Our Ref: AW/6/09/

19th February 2009

Proposed garage.
 4 Arun Way Aldwick

PROPOSED FRONT ELEVATION STREET SCENE - NORTH WEST

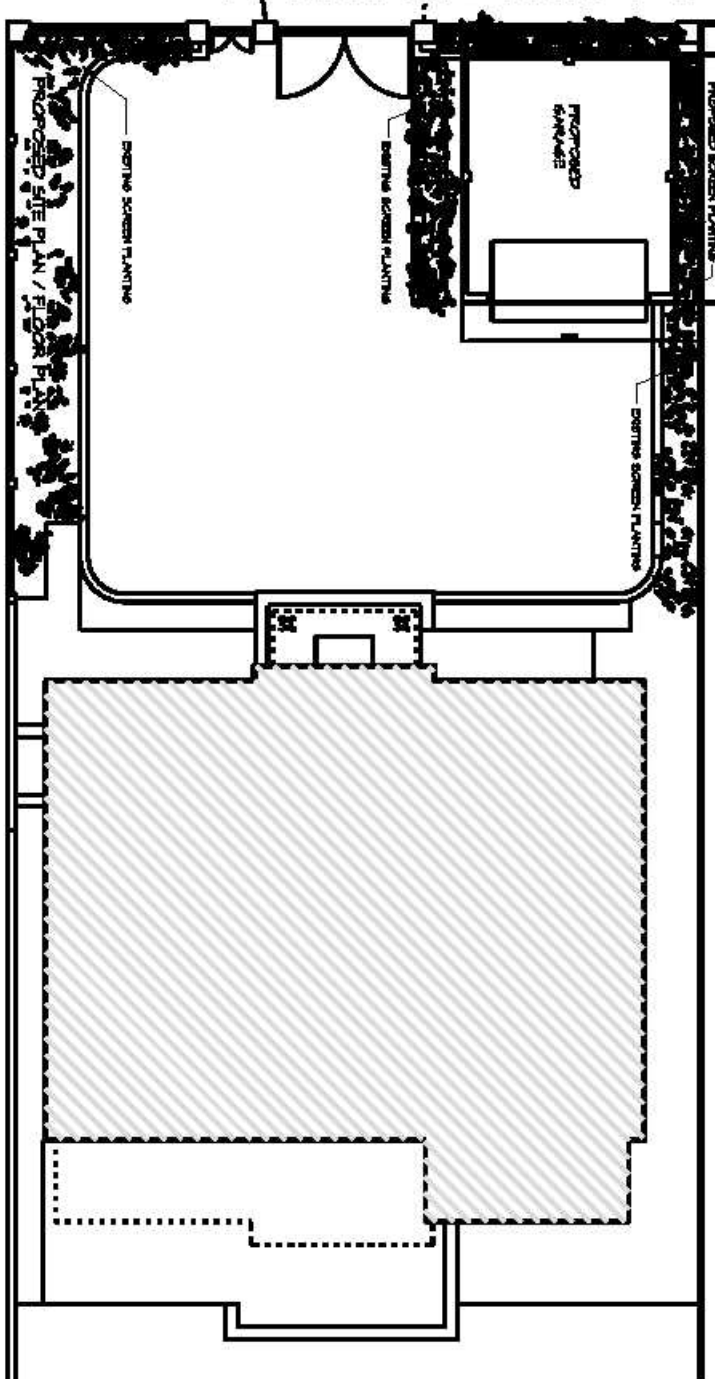
Members felt that the proposed garage to the front of the property would adversely effect the visual amenities of the area. The proposal is therefore contrary to the policies DEV1, CH1, LOC1 of the West Sussex Structure plan and policy Gen 7 of the Arun District Council local plan. ☐
